## Fwd: Gilman st parking spots

**Christopher Branch** <cbranch@portlandmaine.gov>

Tue, Jan 5, 2021 at 9:53 AM

DATE of APPROVAL 12/17/2019 **630-02**

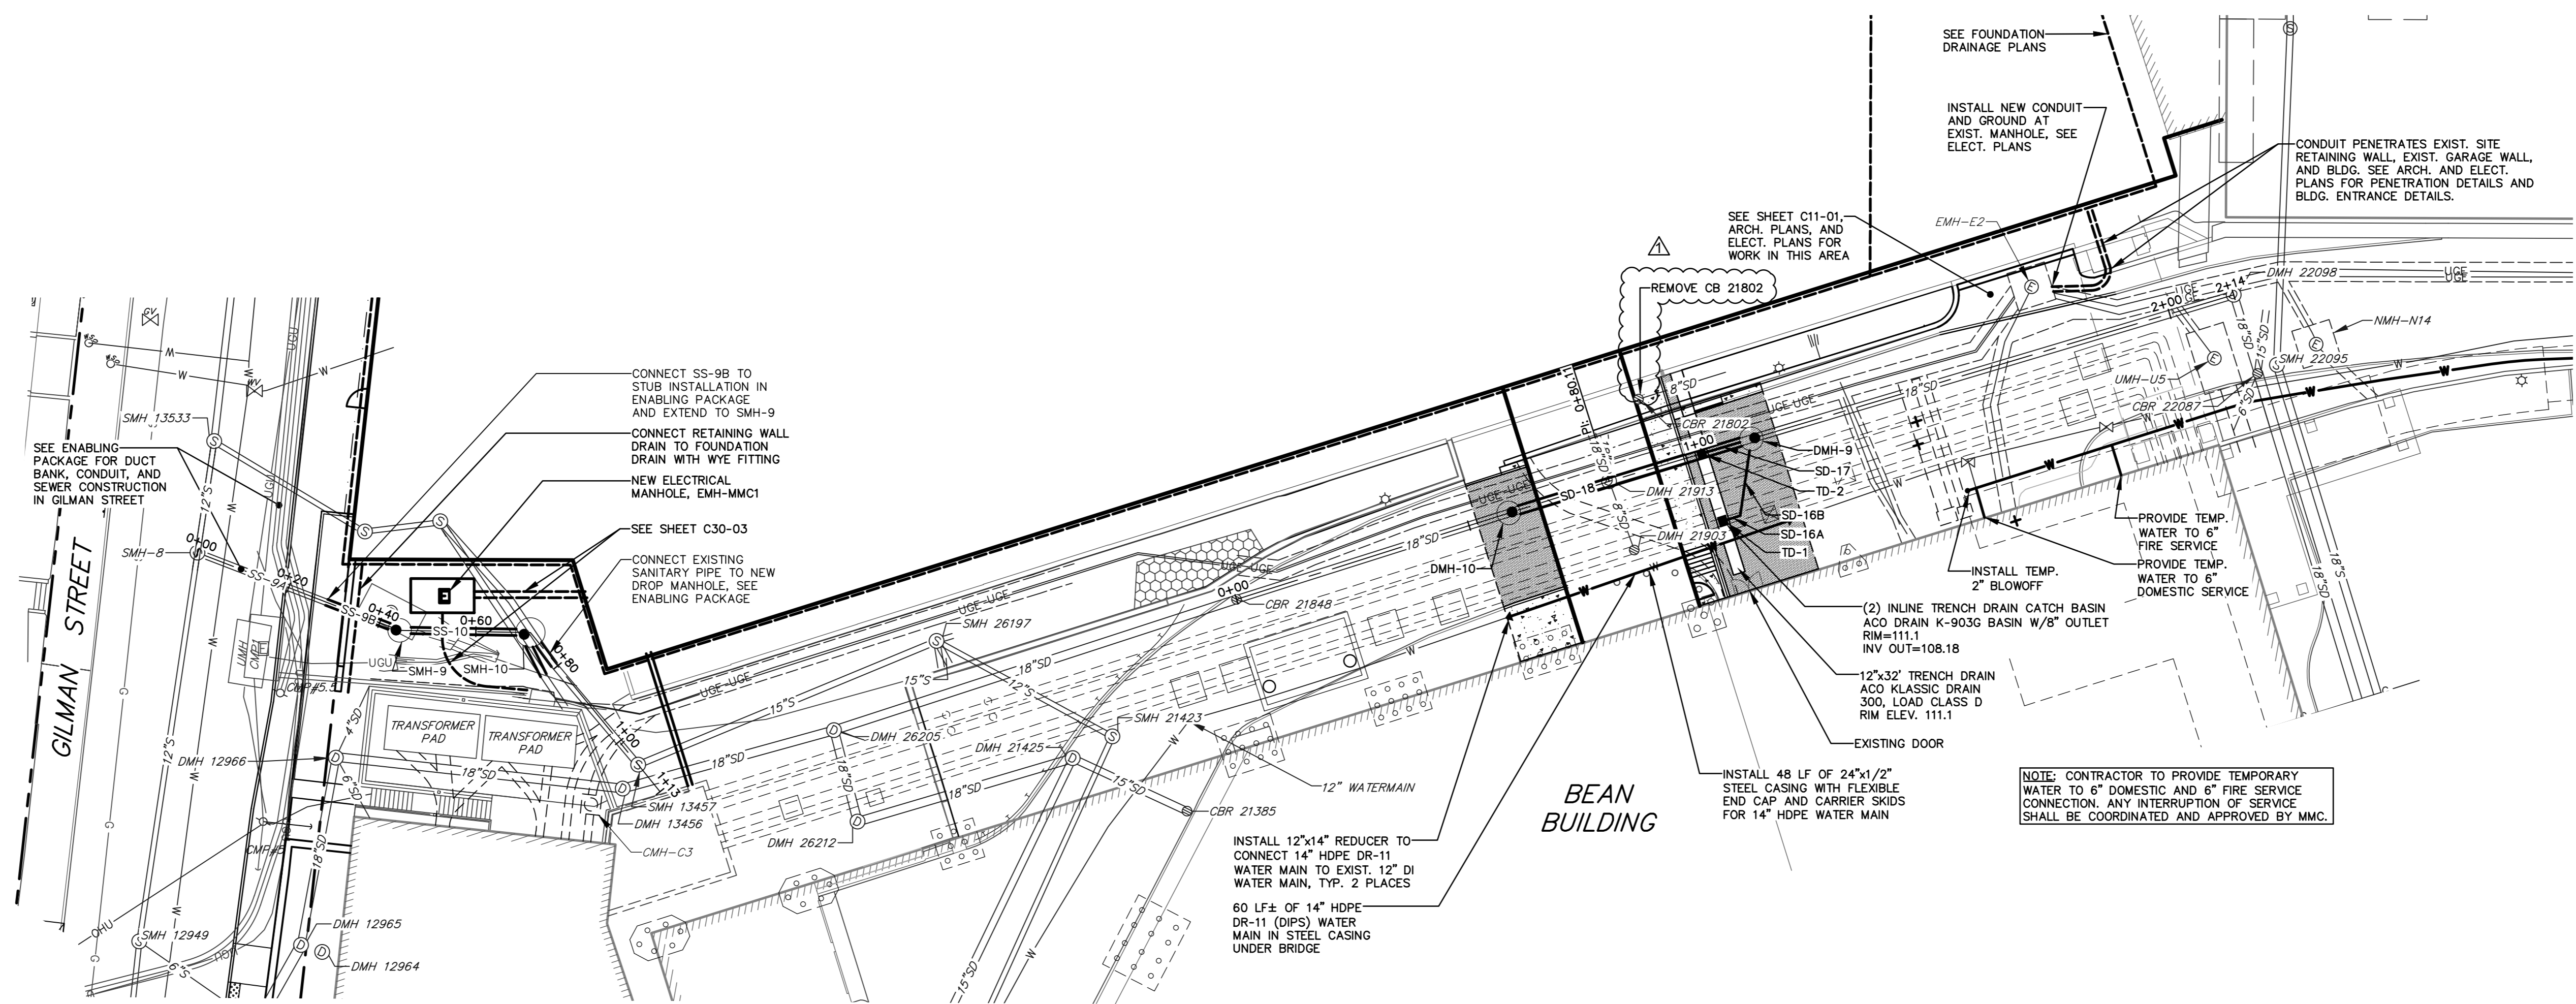
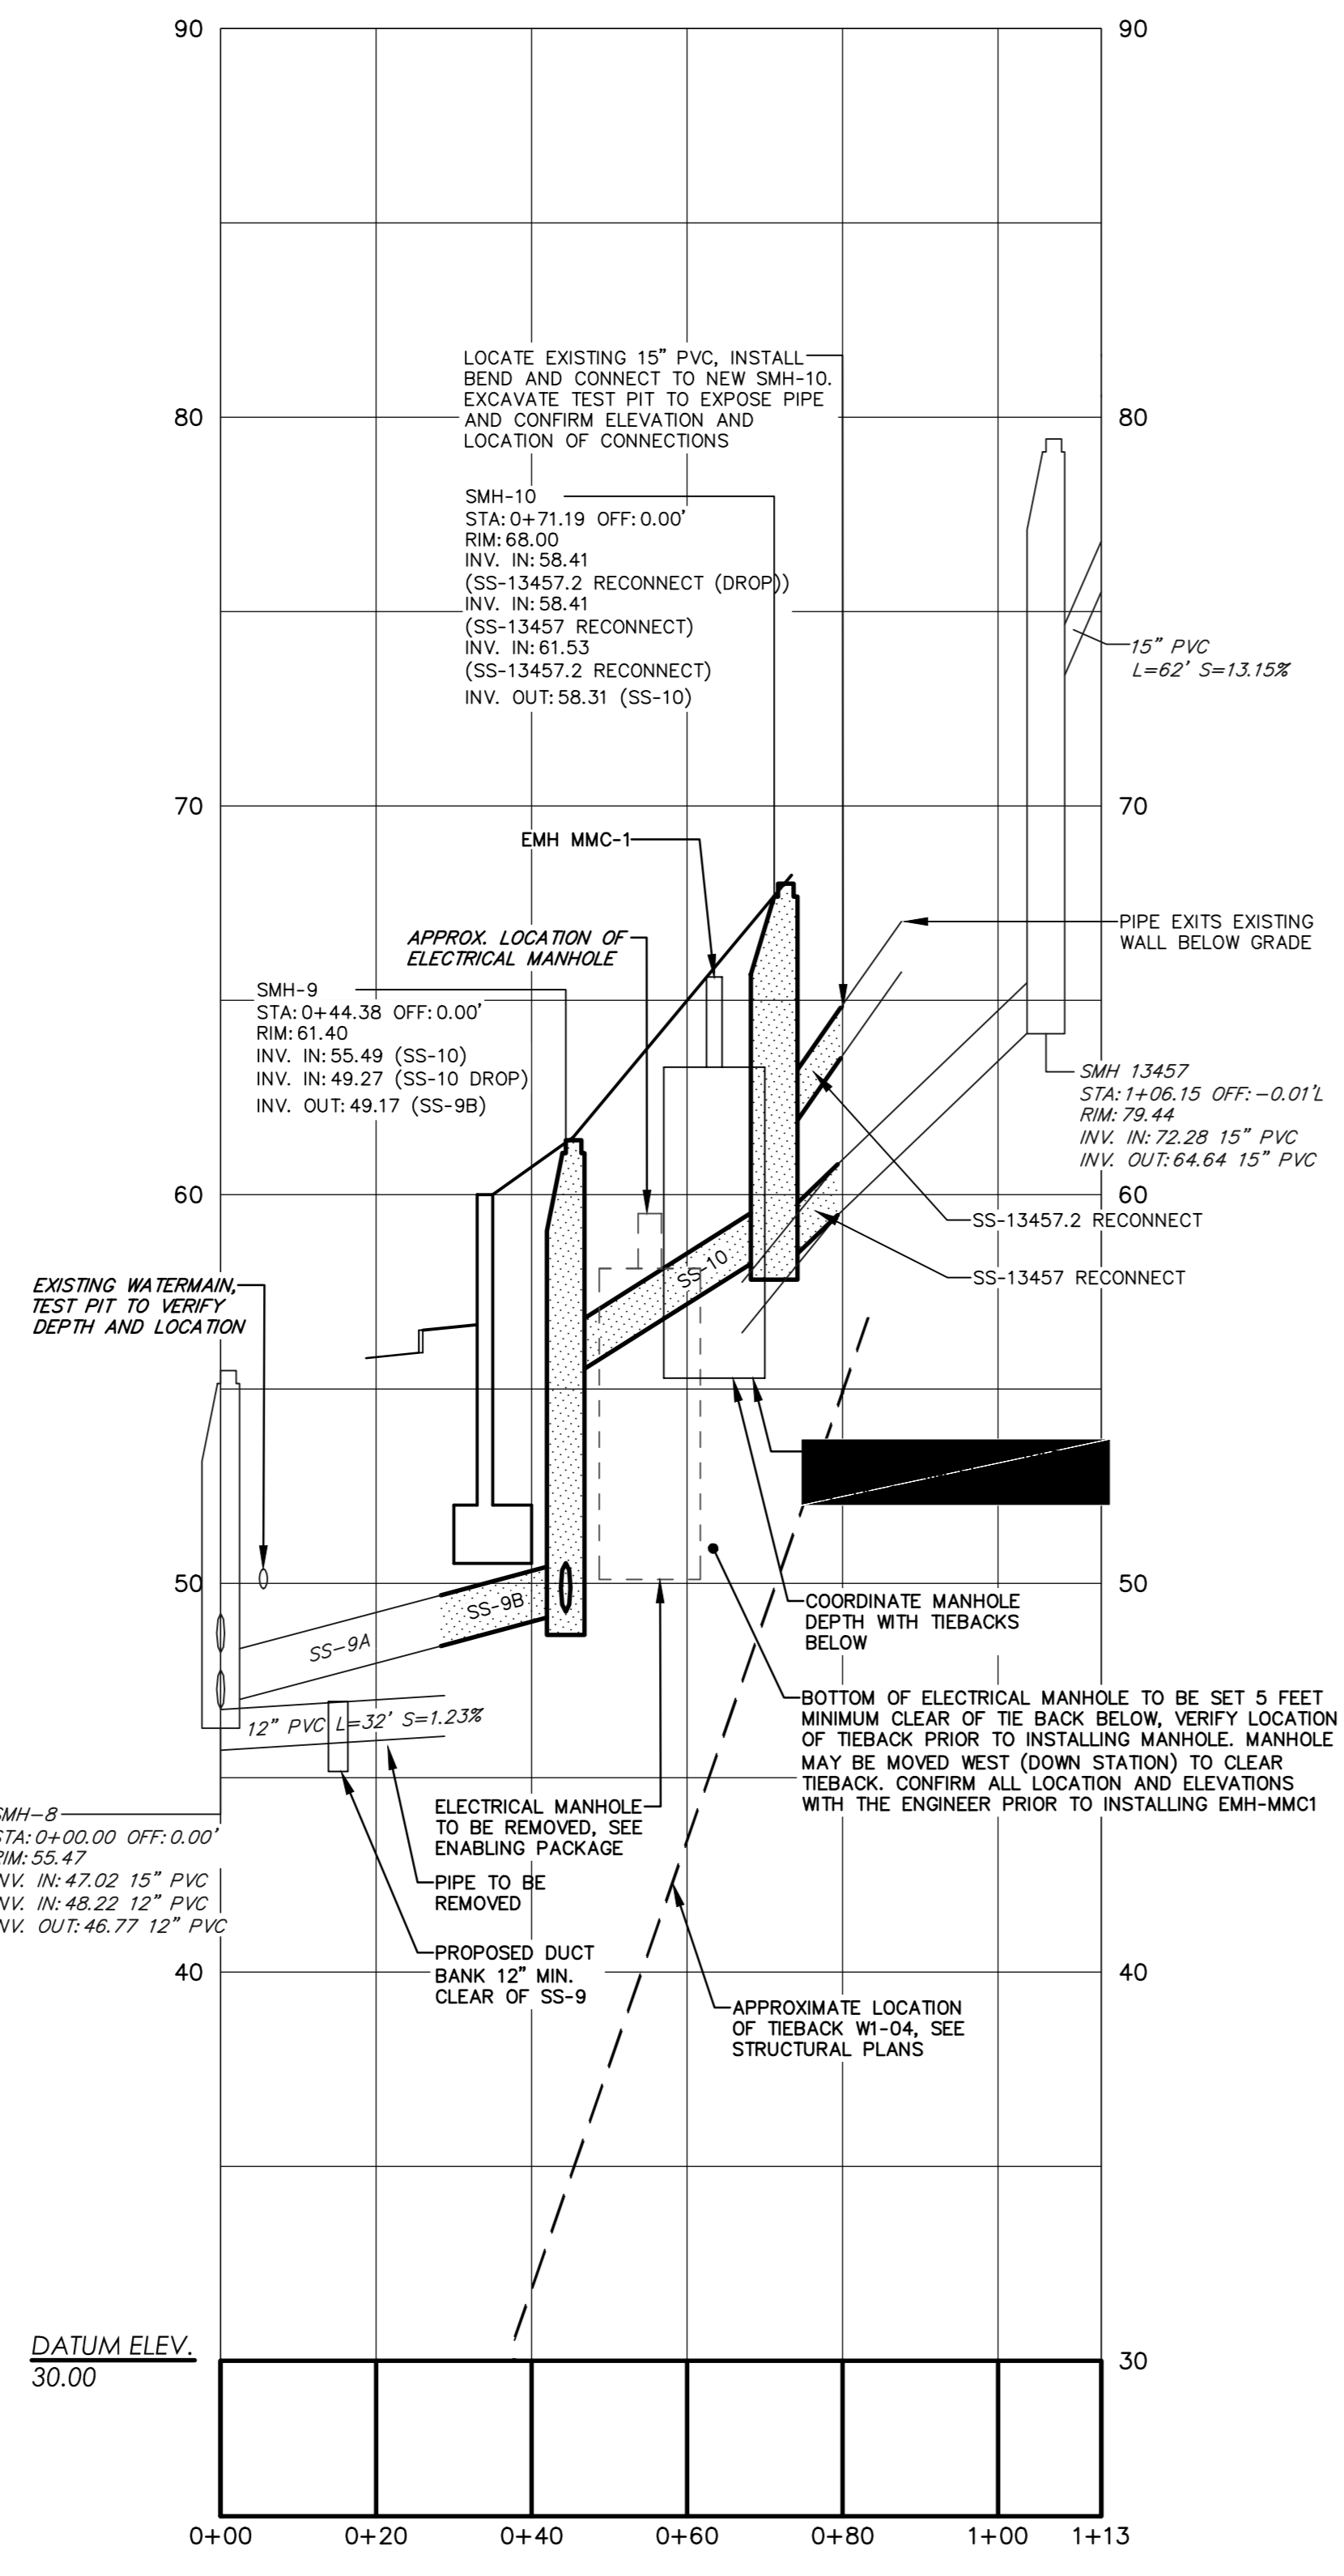
- It appears from the profile they submitted that the tiebacks may extend outside of the City ROW on the side of the street opposite MMC. They show a dimension of 51.7' to the end of the tieback that starts within the ROW, which is 50' wide. This assumes the location of the ROW line on the profile is correct.

- Brad indicated there is an existing storm drain in Gilman it needs to be added to the plan and profile.
- They will need sign offs from all the utilities in the street. The plans show UNITIL, PWD, City Water Resources and there is a duct bank, which I assume belongs to CMP.

- The profile shows the soldier piles and lagging within the City ROW and says they will be removed to a depth 4' below grade. If within the City ROW, it should be lower than 4'.

- I'd like to see profiles for all 4 of the tiebacks on Gilman St.
